Planning Application Reference: 22/02866/OUT

Land East of Ploughley Road, Ambrosden

Planning Application Documents Submission

Drawing Title
**Parameter Plan
Access**

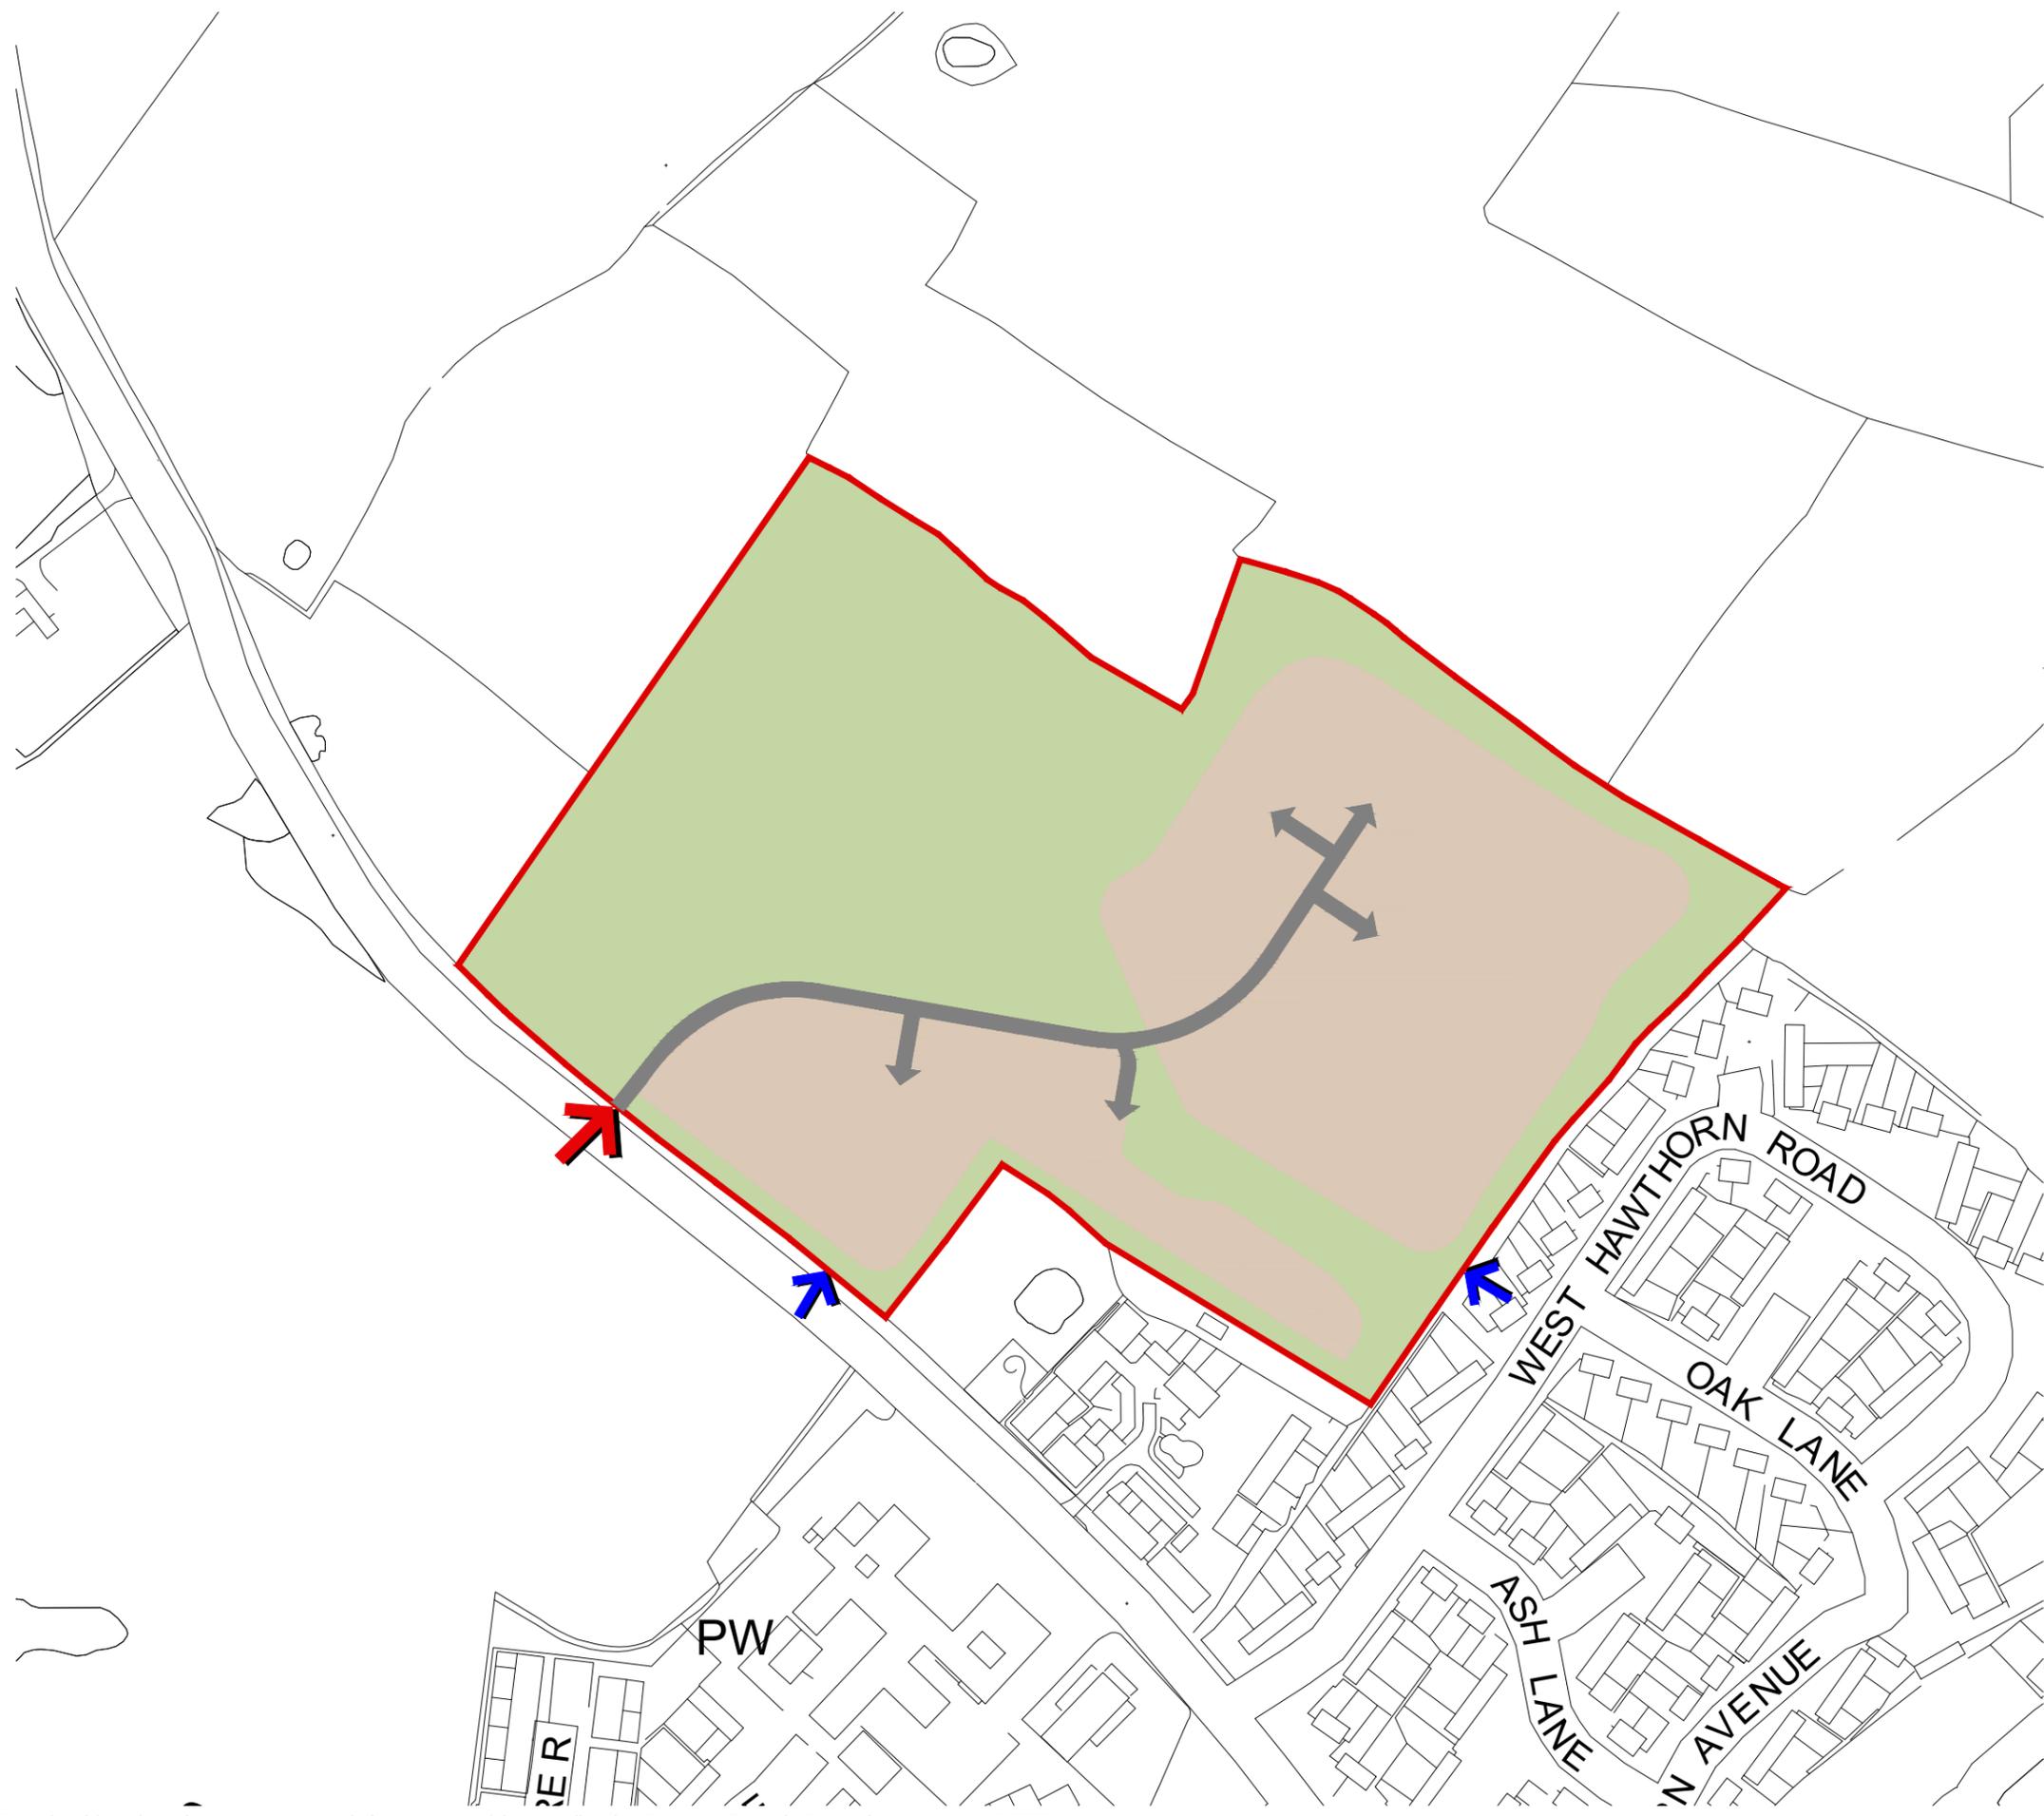
These have been prepared to show a proposed positive change in the indicative location of the pedestrian link where it could join to the east boundary of the site.

The pedestrian link as currently proposed in this location would result in the partial loss of tree group G25 as pictured in the DAS Addendum.

In order to mitigate the impact of the pedestrian link on the existing boundary vegetation, it is proposed that the pedestrian access point (C) is relocated approximately 15 metres north, as shown in the DAS Addendum and on the updated Framework Plan and Parameter Plan Access. This is a relatively minor change but a positive one.

Drawing Title  
Framework Plan

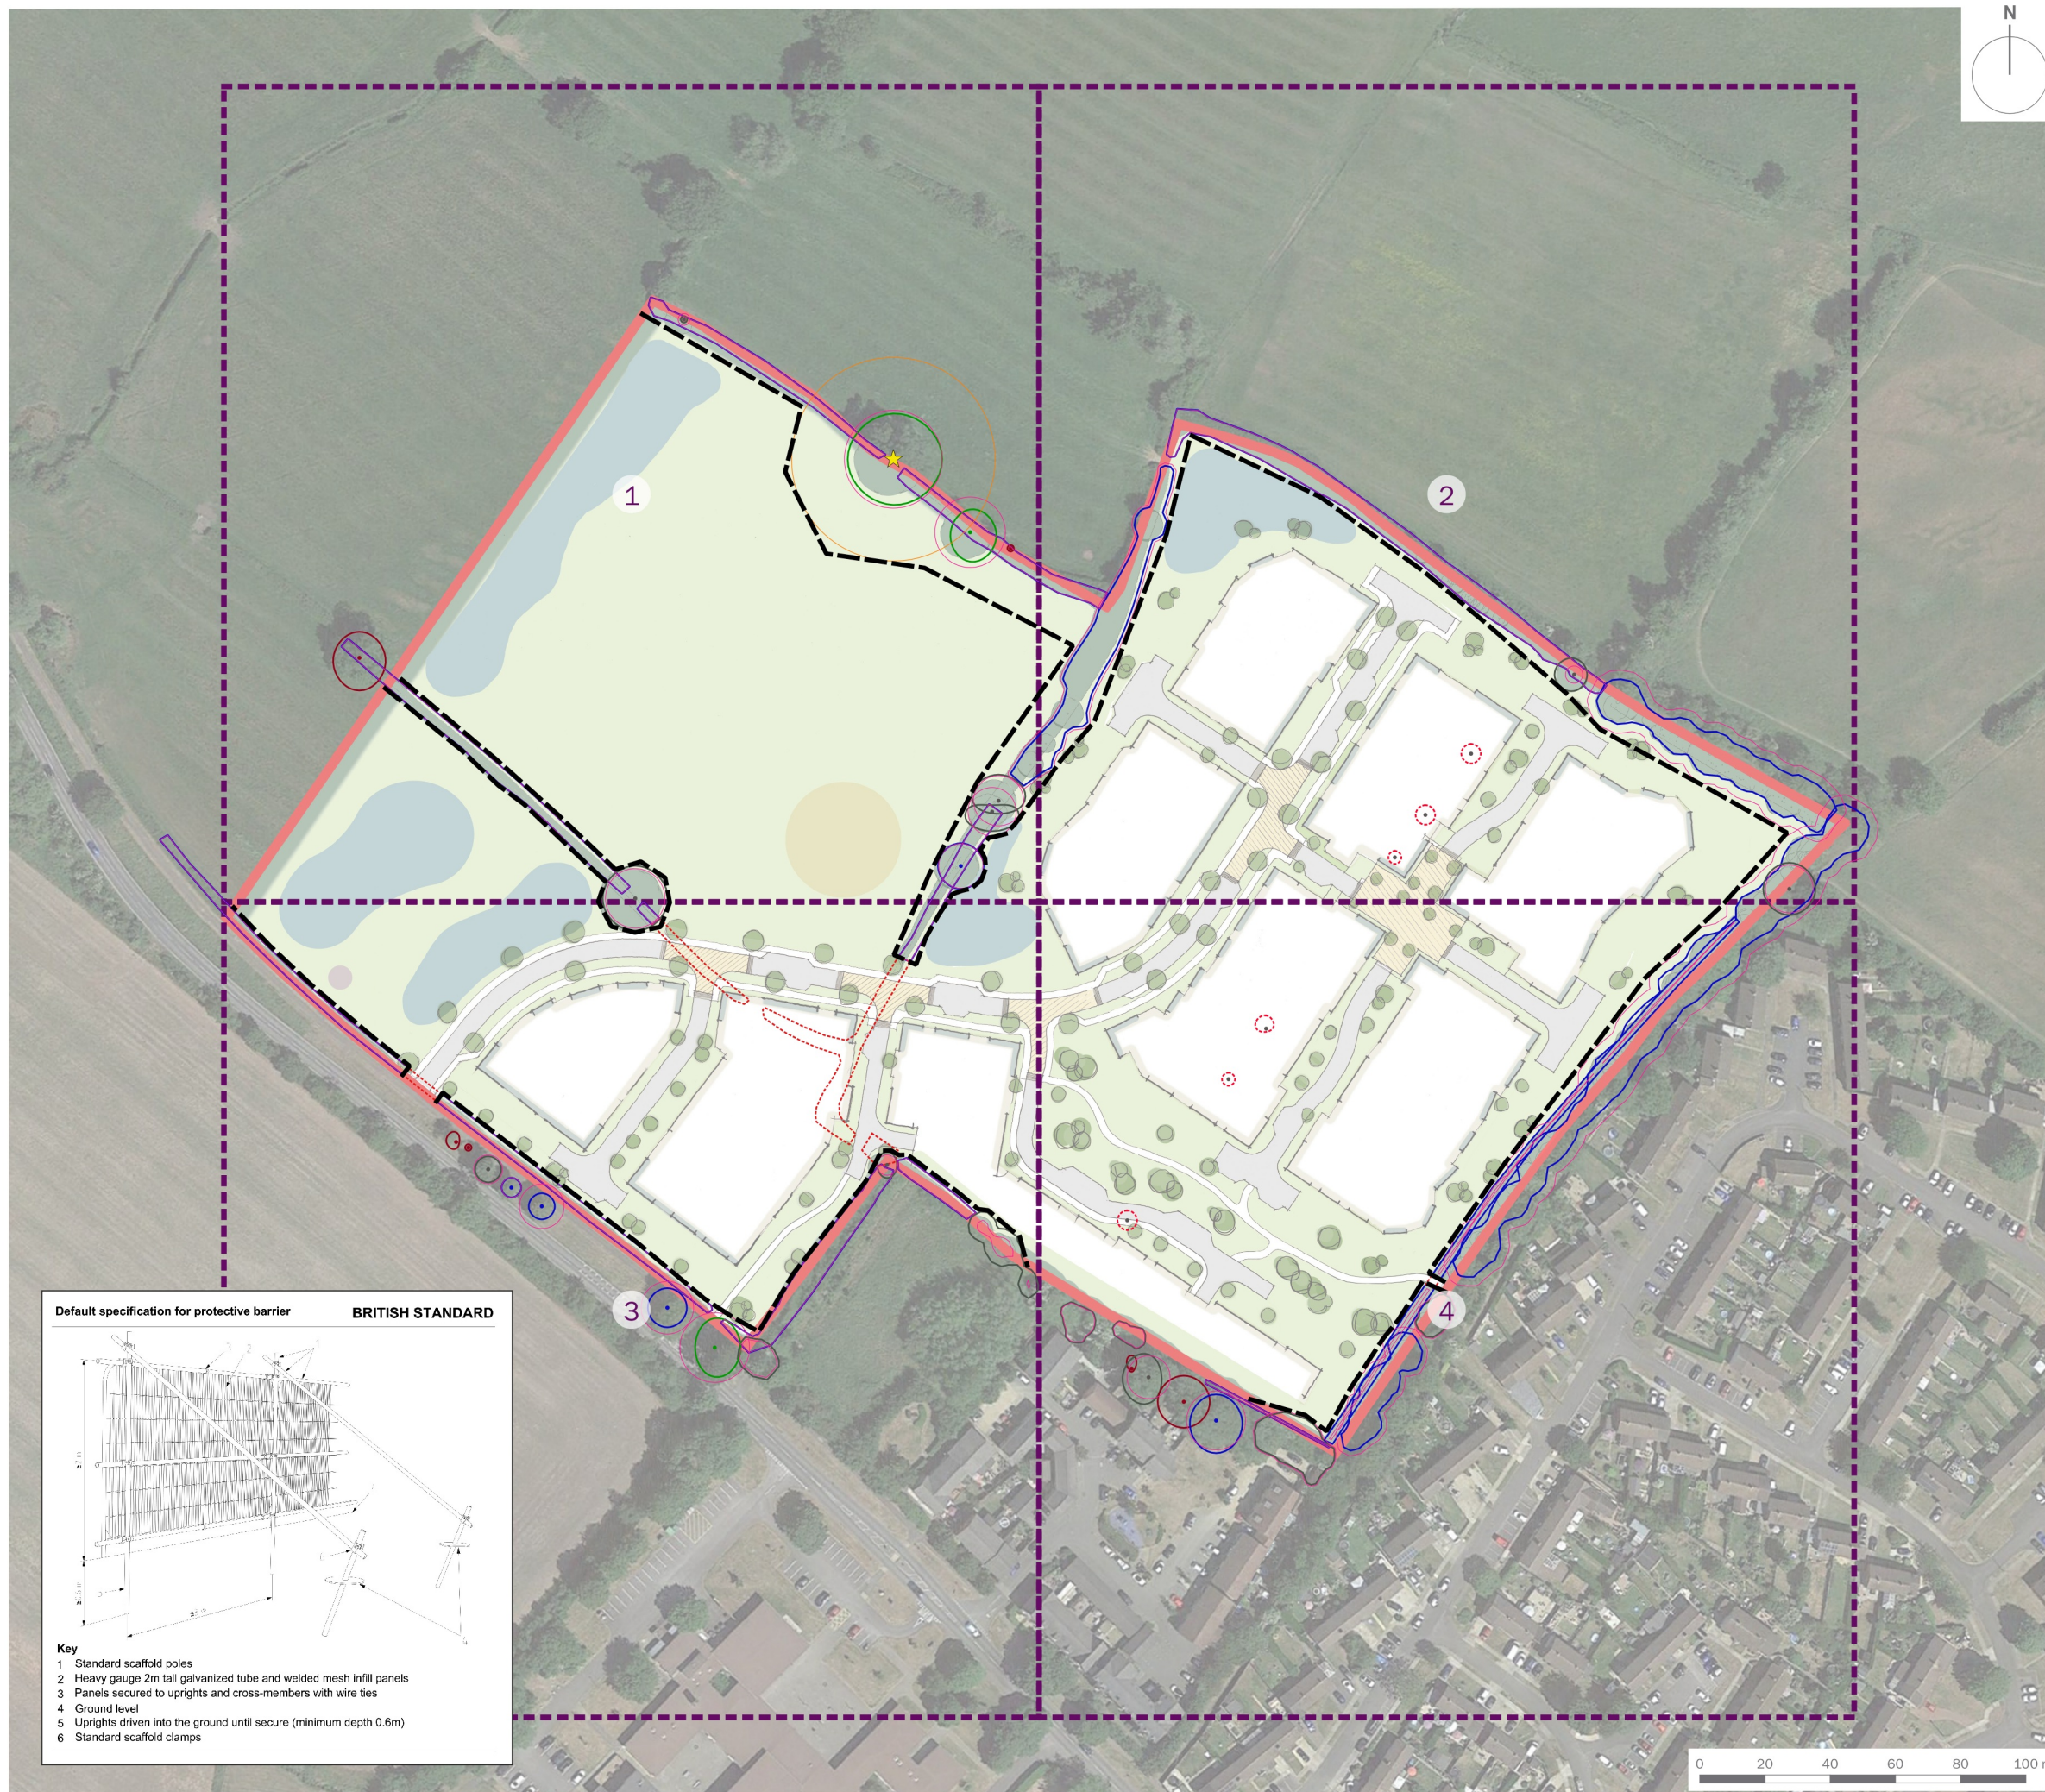
The statement identifies that the revised Framework Plan results in the retention of one category B item (H13) and does not result in the loss of G25 compared with the previous proposals. Therefore the positive change to the pedestrian link to the east boundary of the site as described above results in an improved position in respect of tree retention.
